MDDP & DBPS Amendment

Eagleview El Paso County, Colorado

PCD Filing No.: MDP232

Prepared: February 6, 2024

EAGLEVIEW
EL PASO COUNTY, COLORADO
OVERVIEW MAP - PBMP TRIBUTARY AREAS

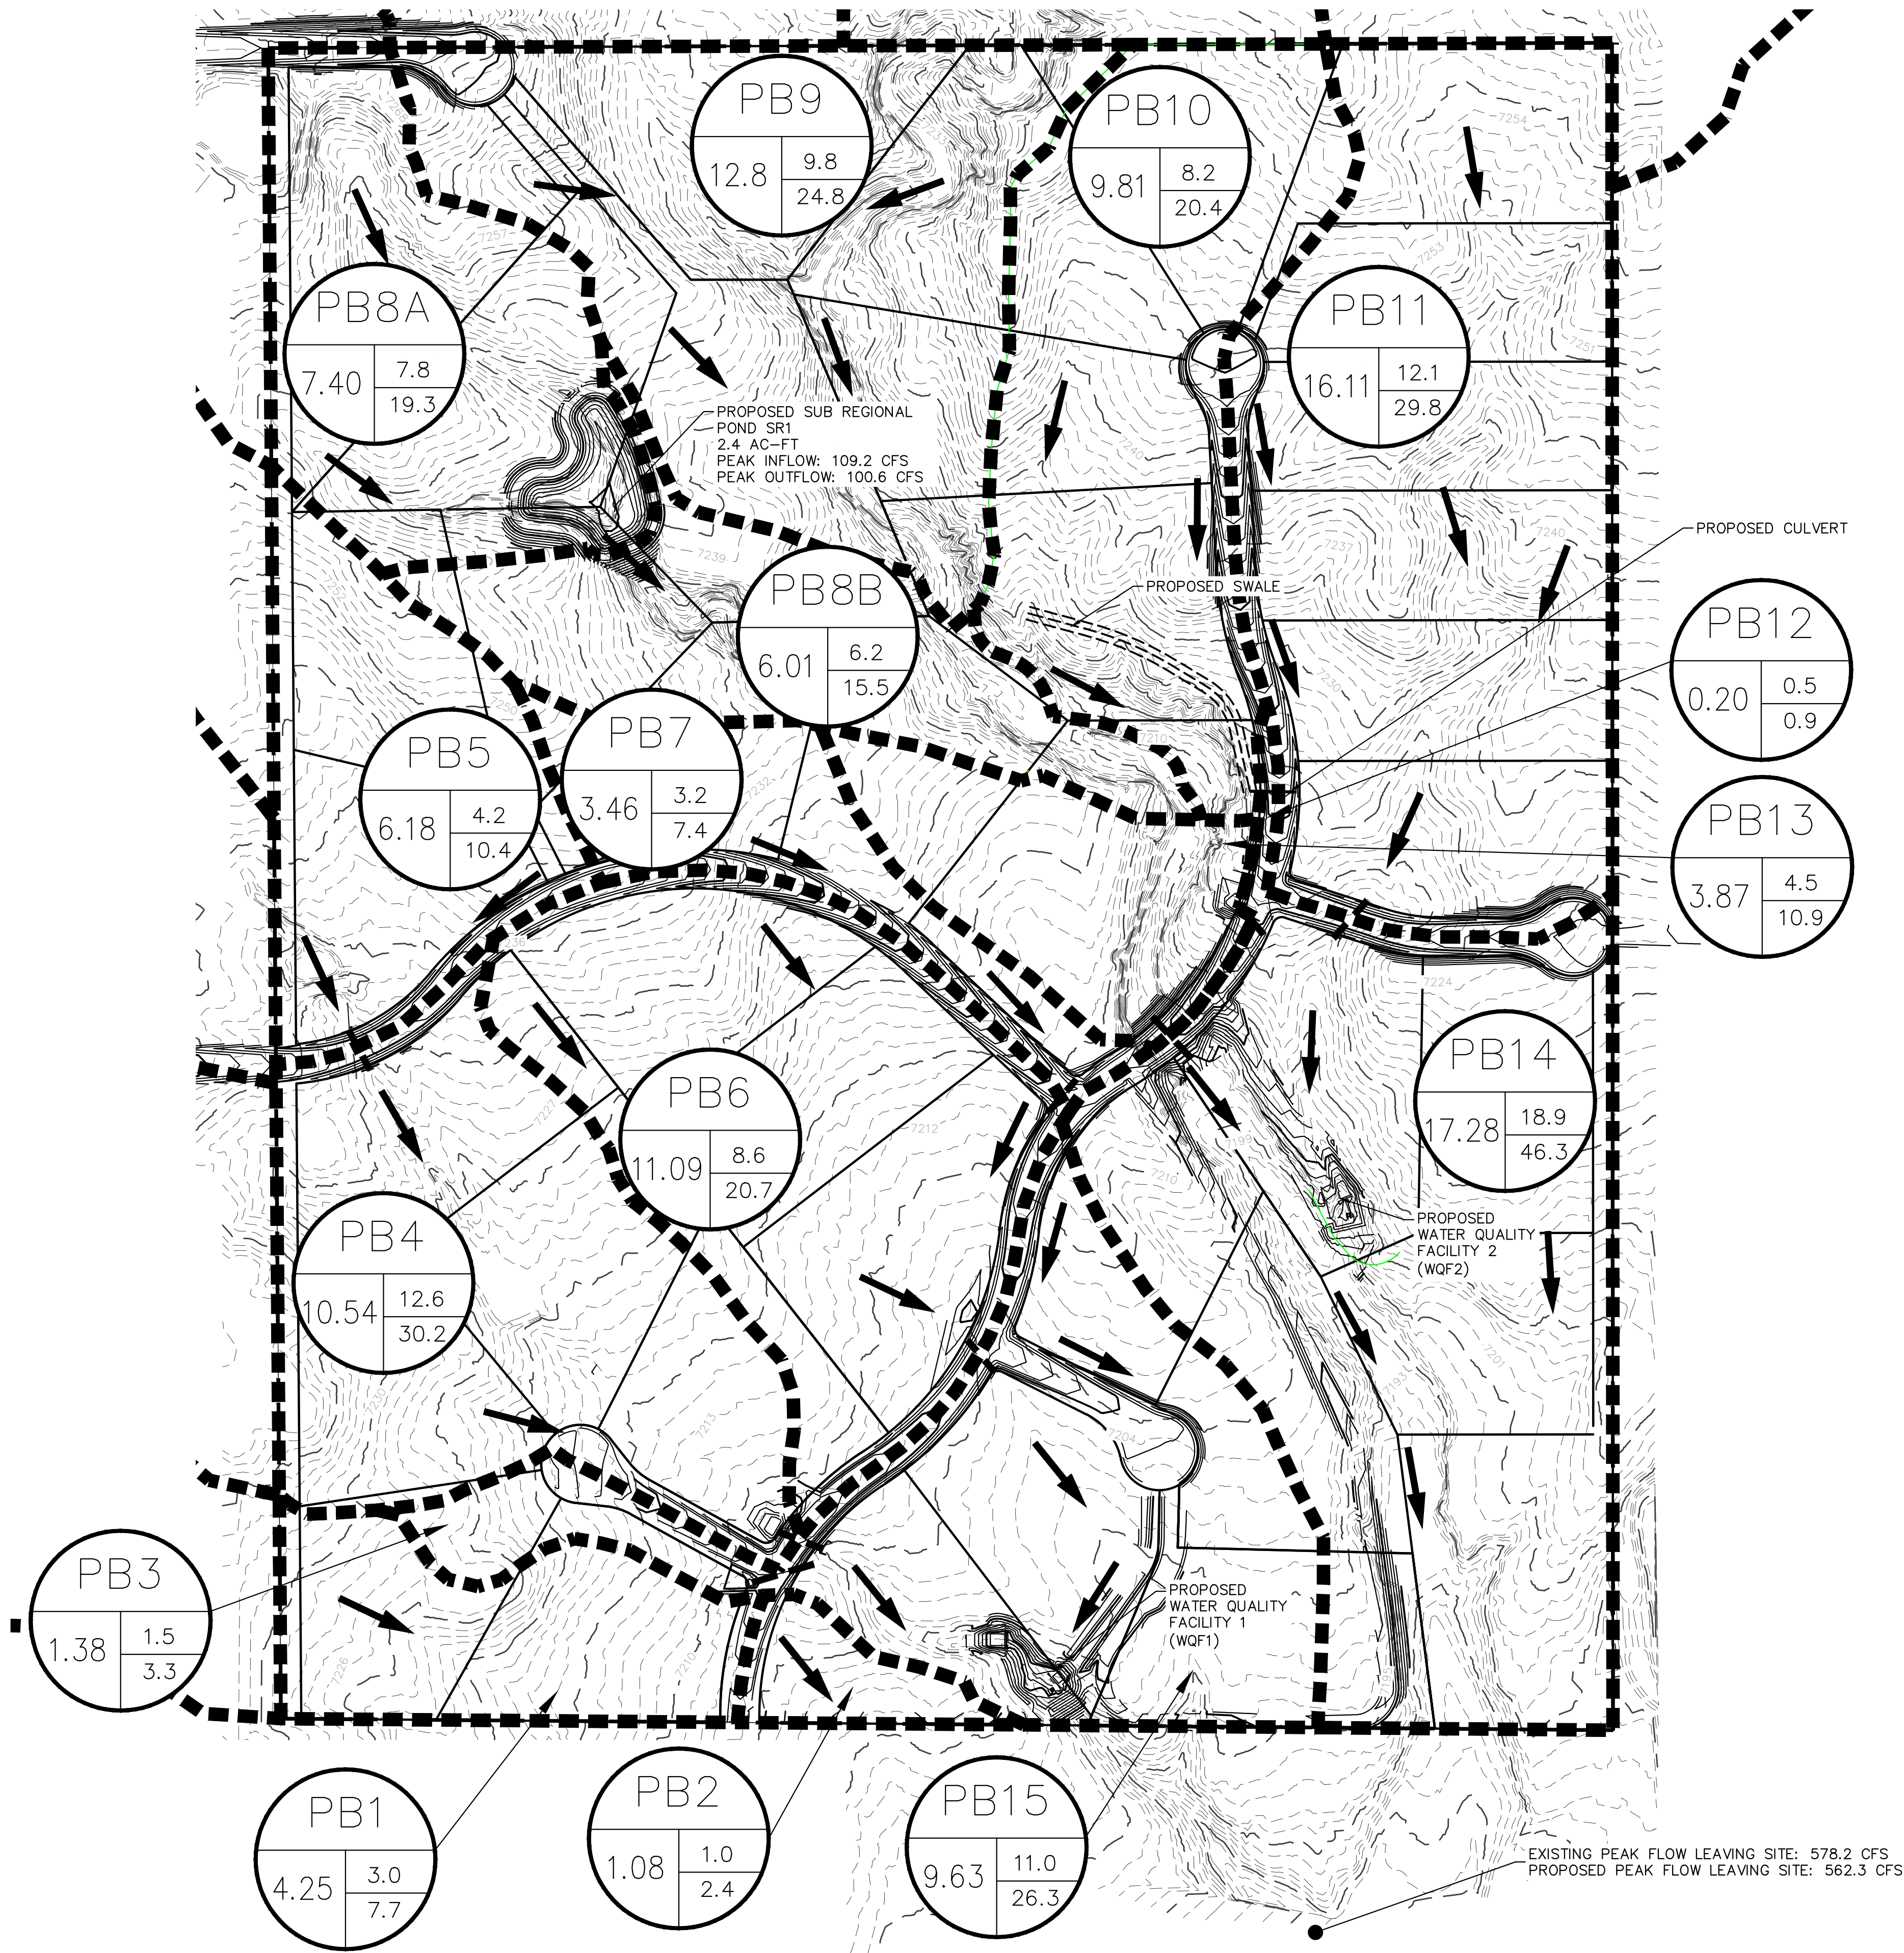
This value may need to be updated again per my comment on the "Overview Map - PBMP Trib Areas."

EAGLEVIEW
EL PASO COUNTY, COLORADO
PROPOSED CONDITIONS DRAINAGE MAP

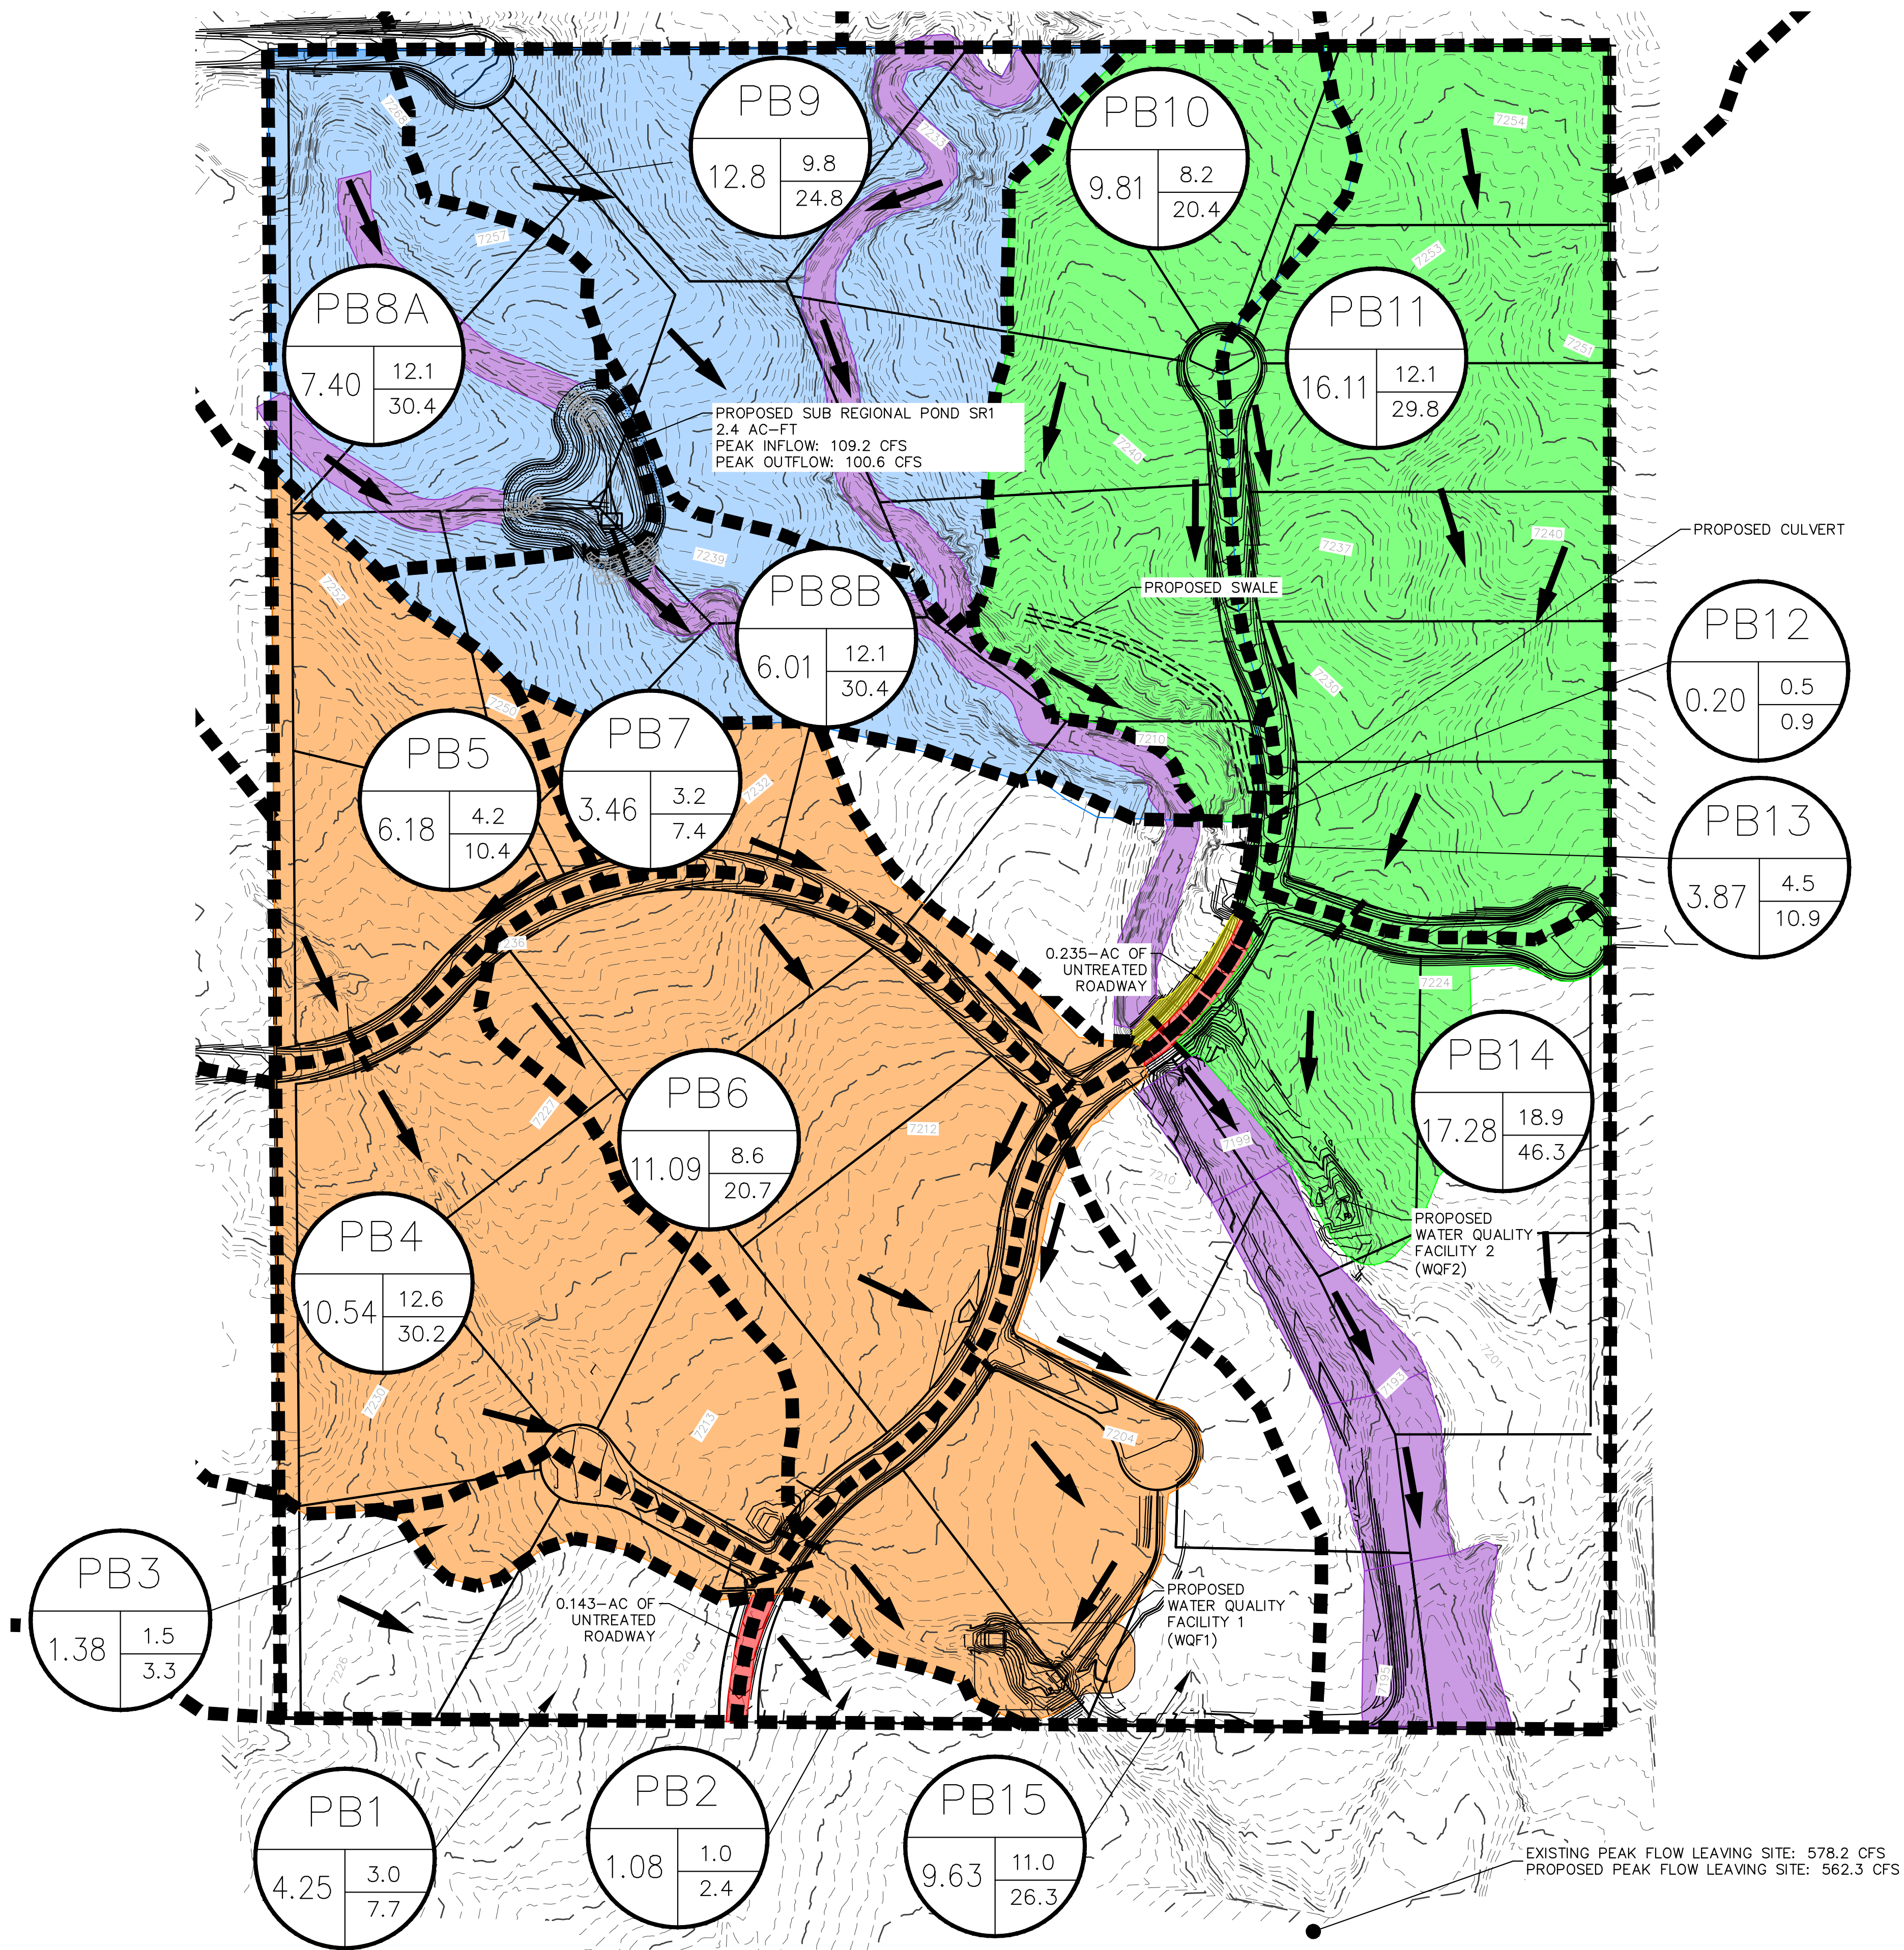
Basin P7 does not appear to match the label on the proposed drainage map.
